Rezoning Petition Review

Date of Review: February 22, 2021 (***Revised March 22, 2021***)

Rezoning Petition #: 21-018

Location of Property: Approximately 10.81 acres located in the western quadrant of the intersection of N Poplar St and West 28th St, south of Atando Ave.

BOUNDARY AND TOPOGRAPHIC SURVEY BASE MAP TAKEN FROM A SURVEY PREPARED BY A.G. ZOUTEWELLE SURVEYORS, DATED JANUARY 16, 2008

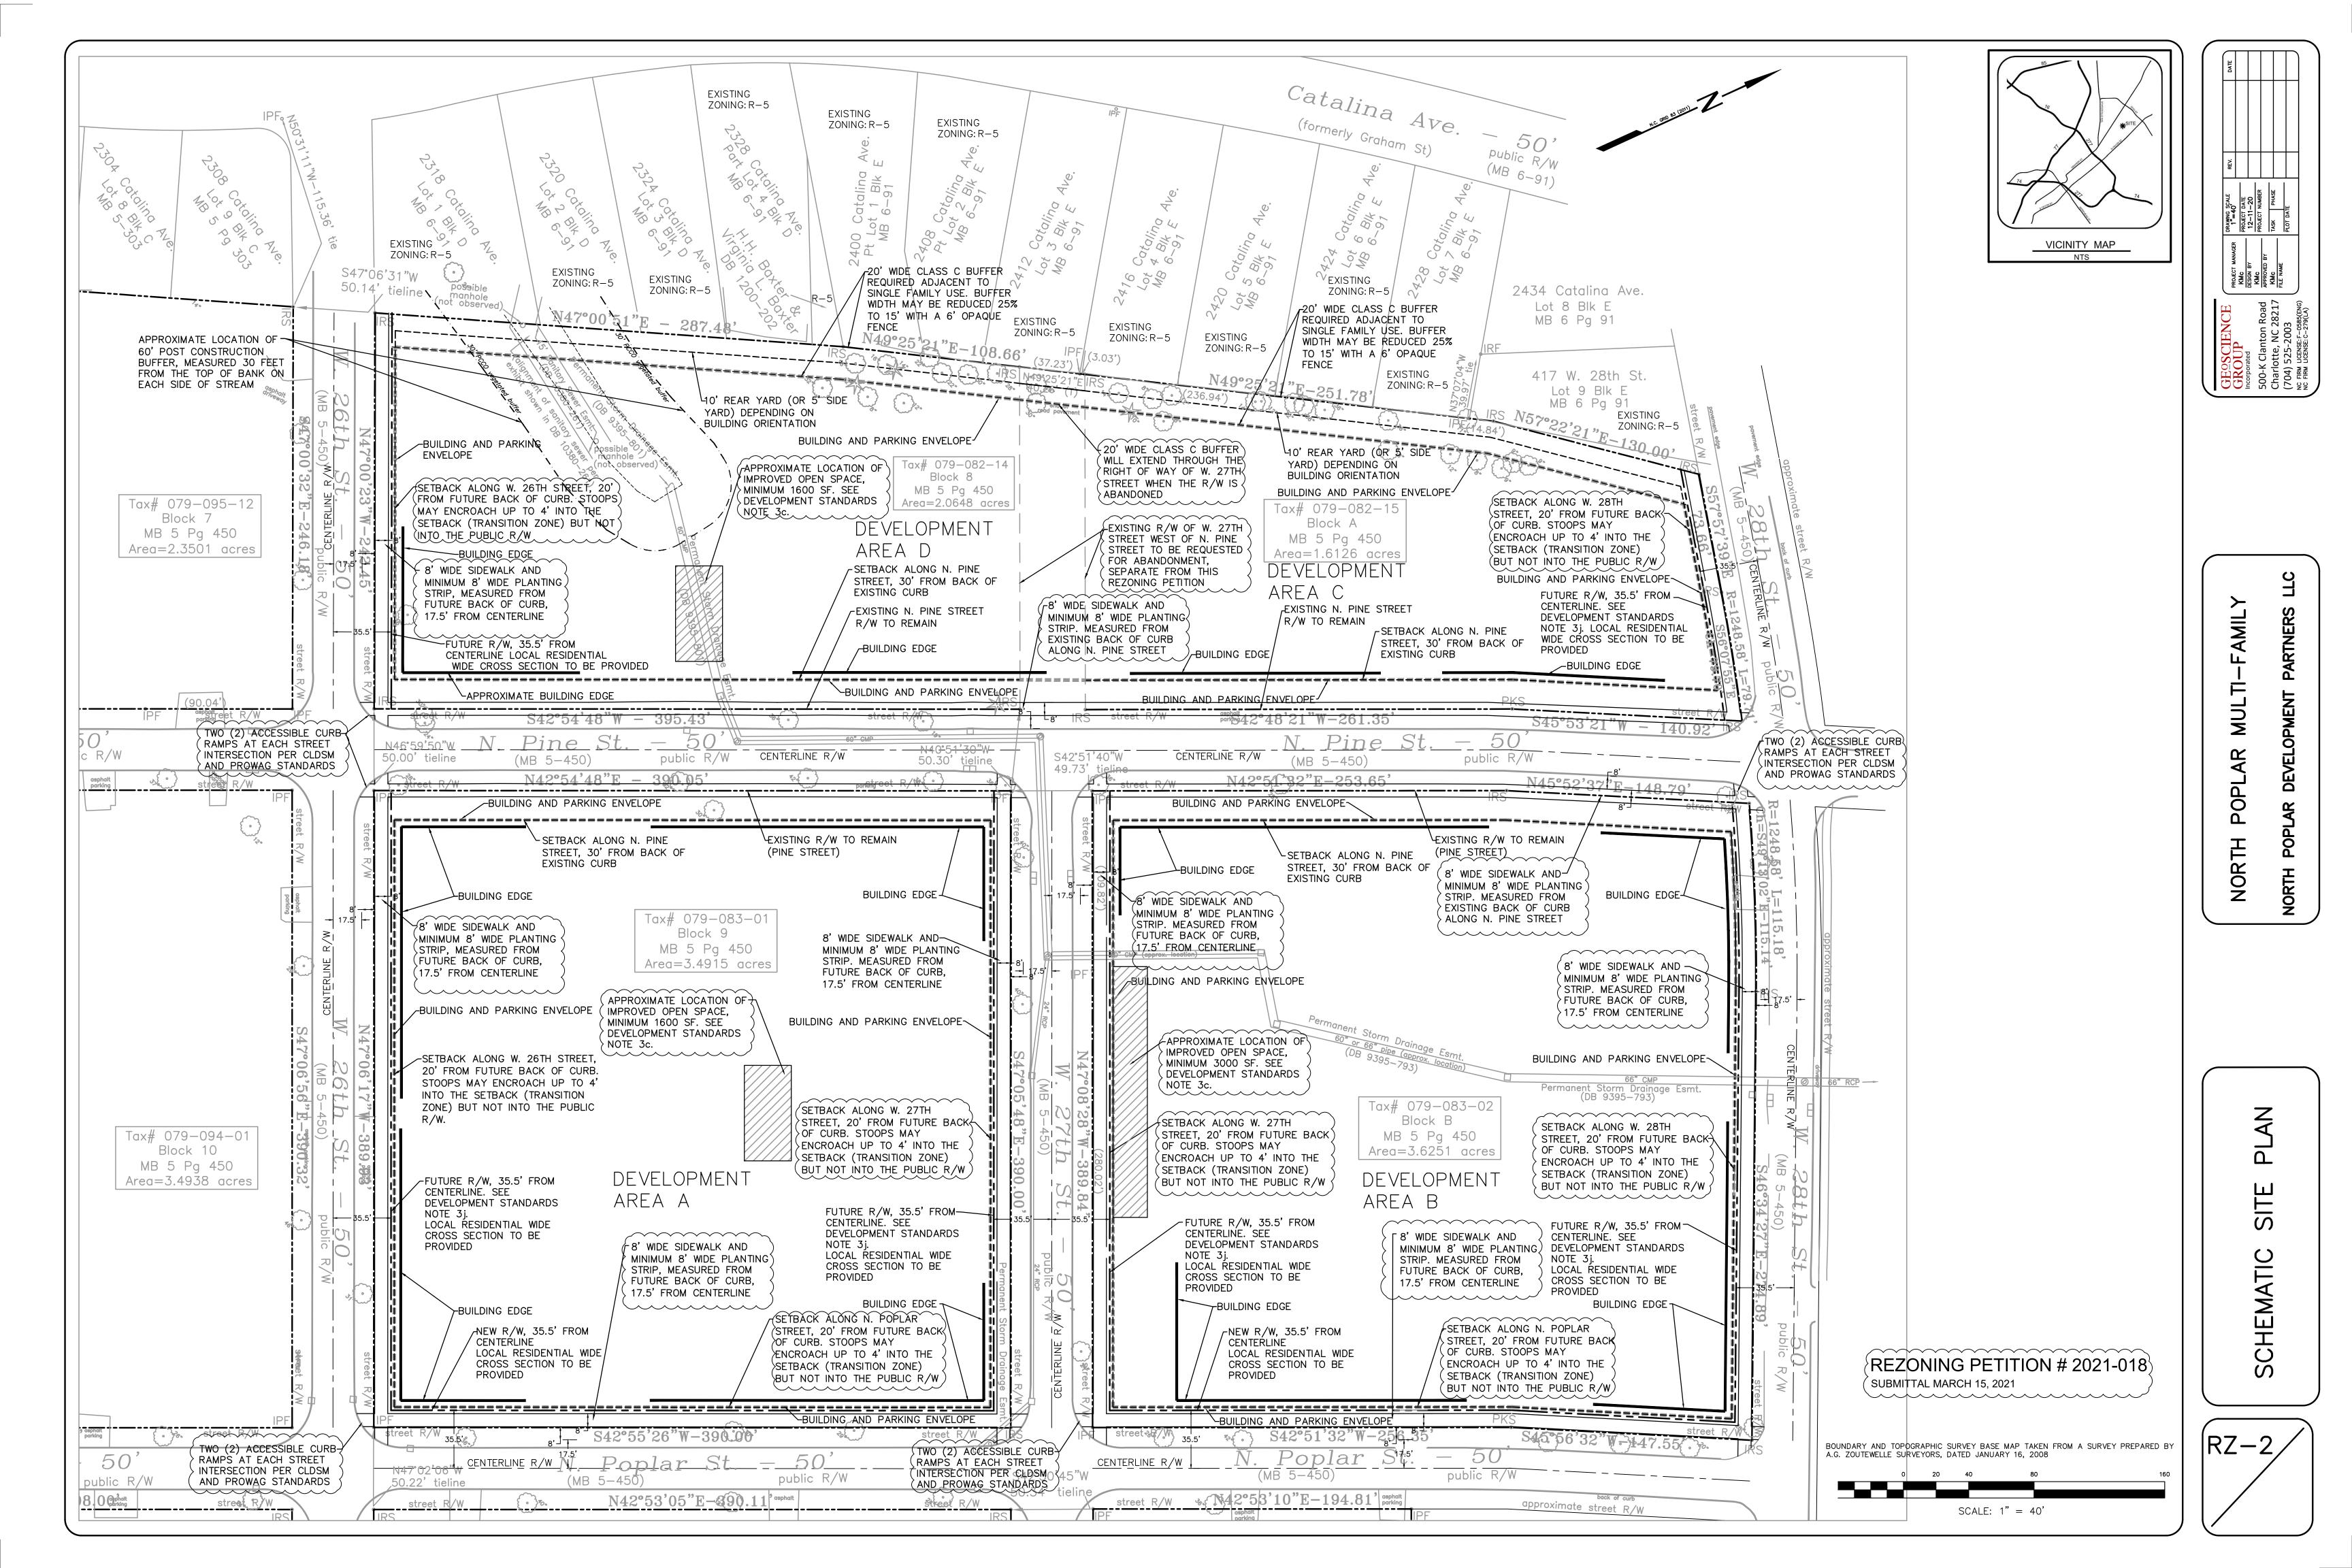
Concerning Storm Water: City of Charlotte GIS data indicates a 30-ft PCSO buffer across the site. Please show and label *Potential 30-ft PCSO Buffer* on the site plan. Any increase of impervious area within such buffers may not be allowed and is not approved with the rezoning process. Stream Delineation Reports are subject to review and approval by Charlotte Storm Water Services. Please include the following note under Environmental Features: *“Development within any SWIM/PCSO Buffer shall be coordinated with and subject to approval by Charlotte-Mecklenburg Storm Water Services and mitigated if required by City ordinance. Petitioner acknowledges intermittent/perennial stream delineation reports are subject to review and approval upon submission of development plans for permitting and are not approved with rezoning decisions.”*

Due to revisions (3/22/21): No additional recommendations are needed at this time.
